Development Review Board Comments

Project Number: 1003748
Application Number: 04DRB-01660

Tracts 8-E & 9-E, Lands of Hollingsworth

DRB-1003748

18 OCTOBER 2004
2 2

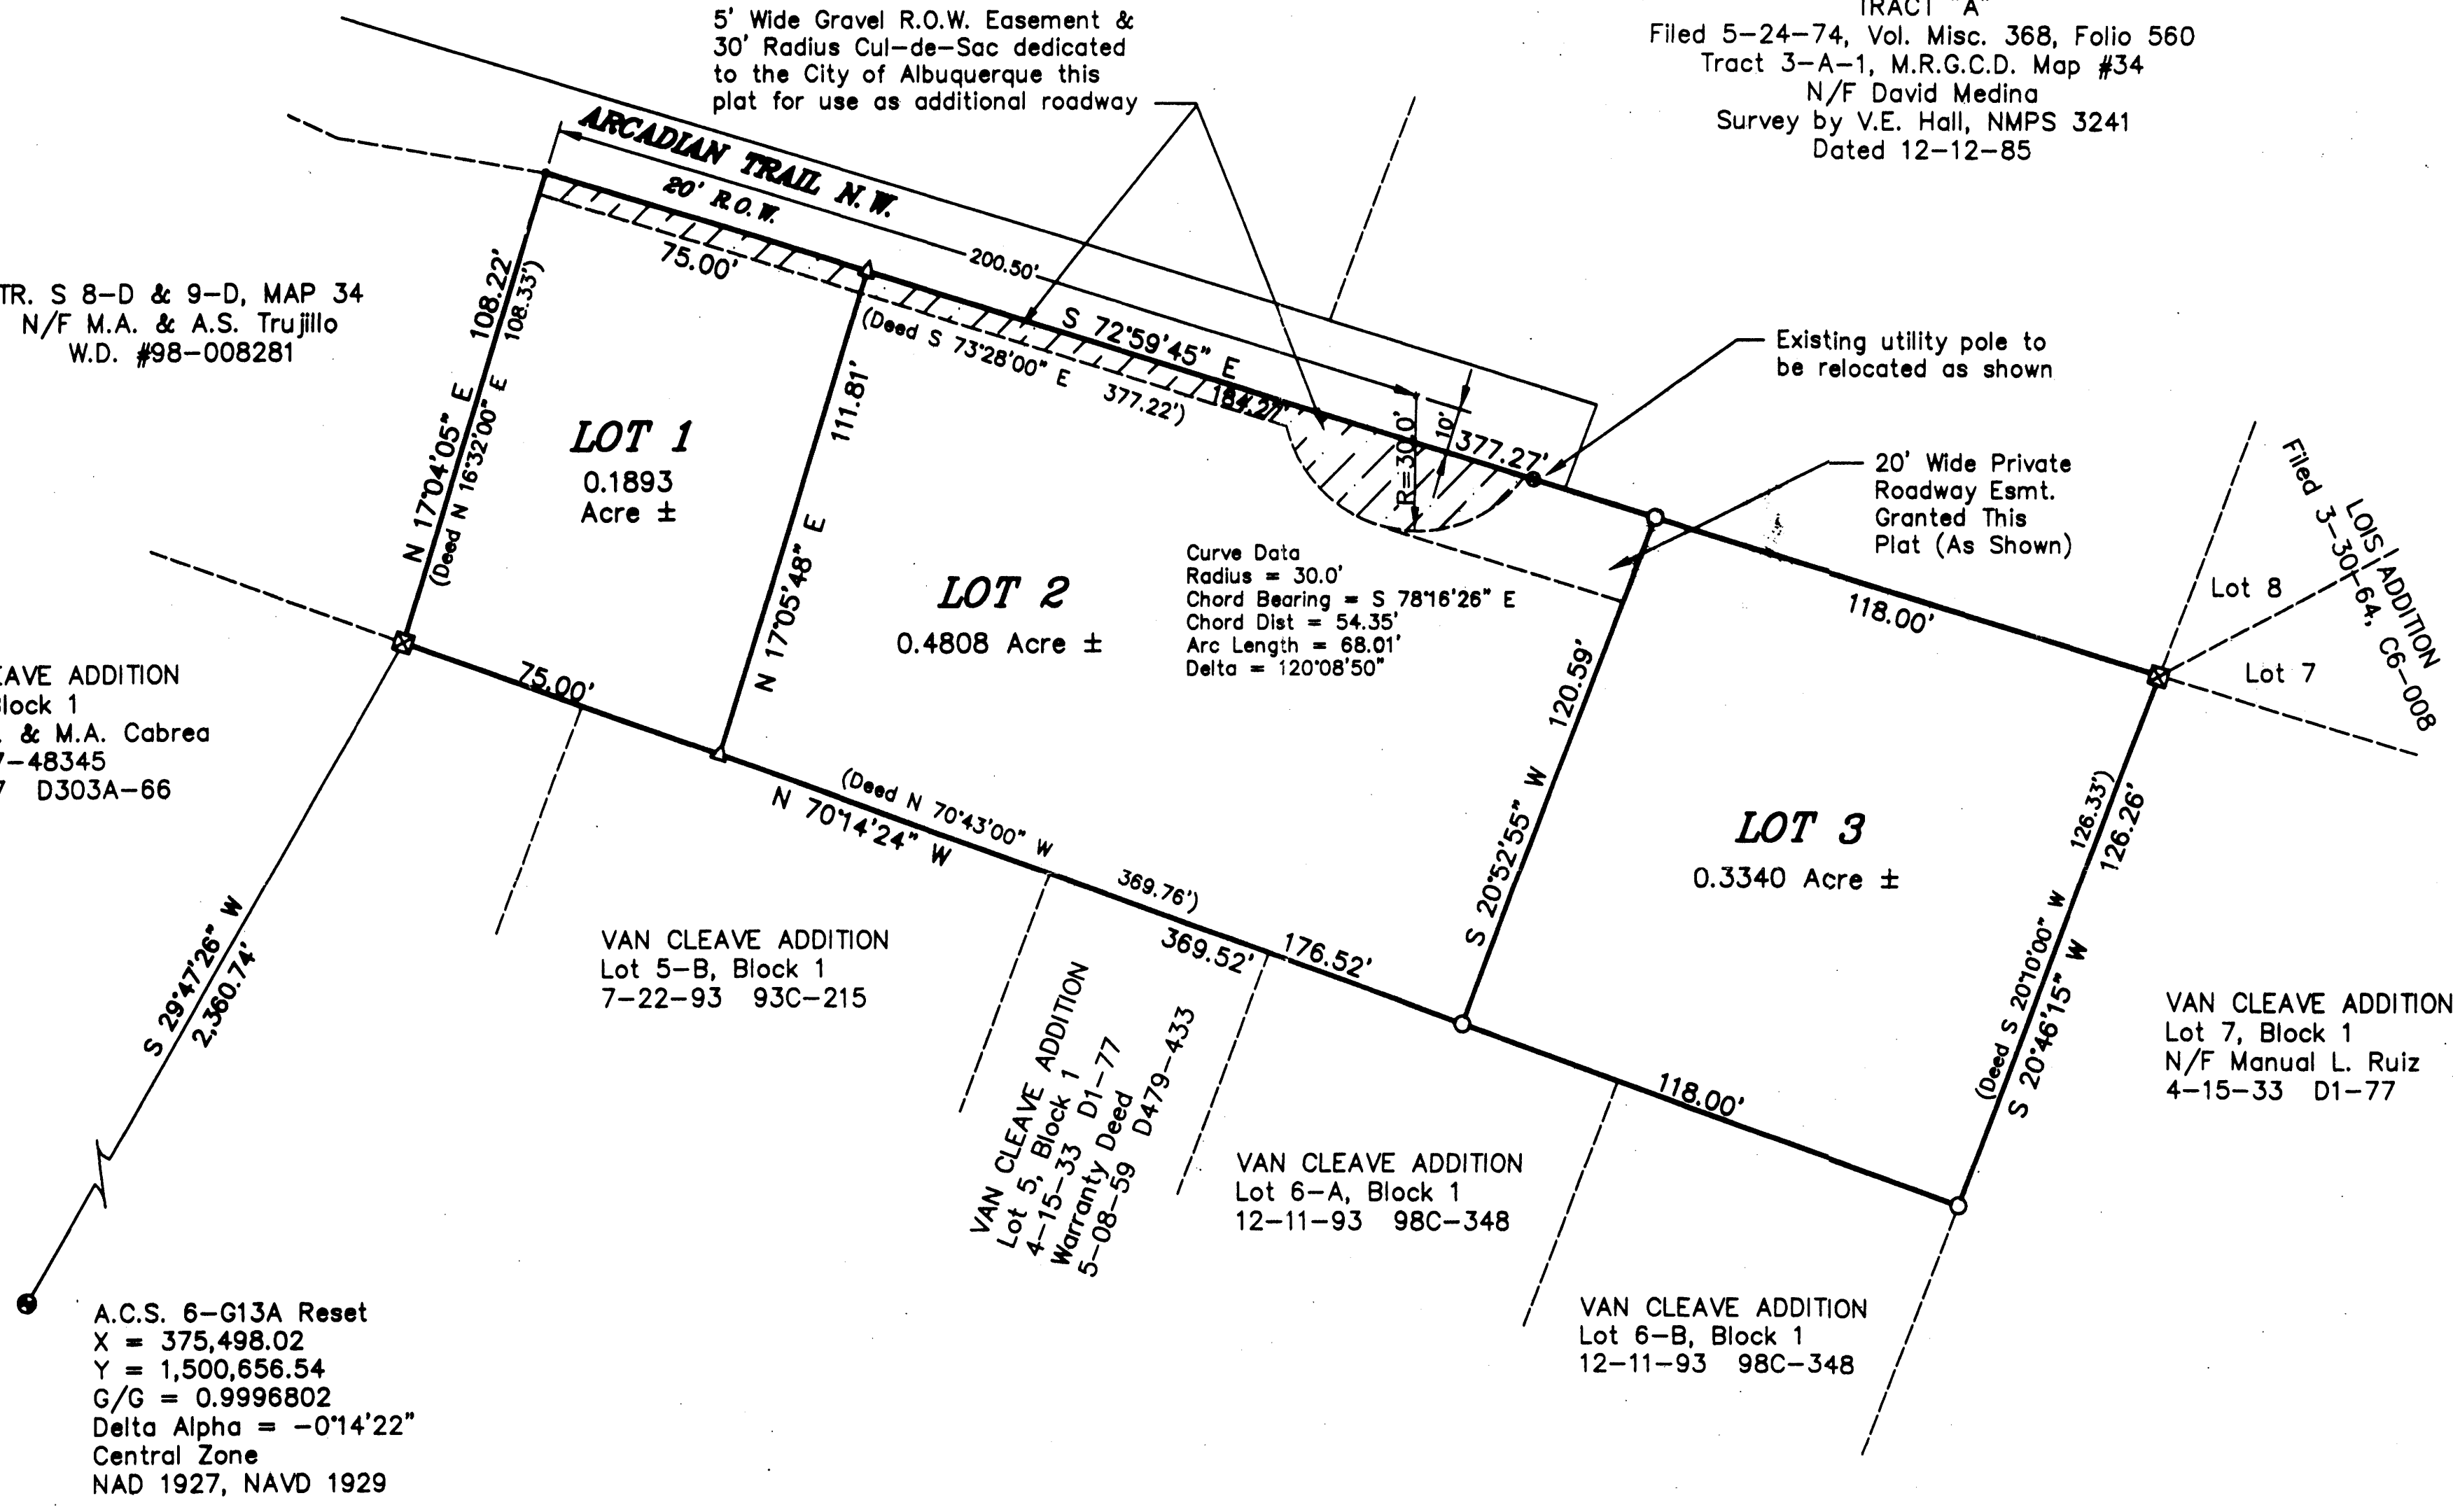
- 1) Maintenance and beneficiary of 20' private easement needs to be shown.
- 2) The hatched area needs to be dedicated as right-of-way (not an easement).
- 3) The existing utility pole needs to be moved by the property owner.

3) Plat does not show a public sewer easement for the exist SAS on north side of your property.

RA2 zoning requires a minimum of 10,890 square feet for each lot and a minimum lot width of 75 feet. Lot 1 does not have the required square footage. Perhaps Lot 2 could contribute enough square footage. Because a sketch of existing buildings was not provided, a determination could not be made if this would be possible.

25' rear yard setback required
Existing house on lot 2
faces lot 3
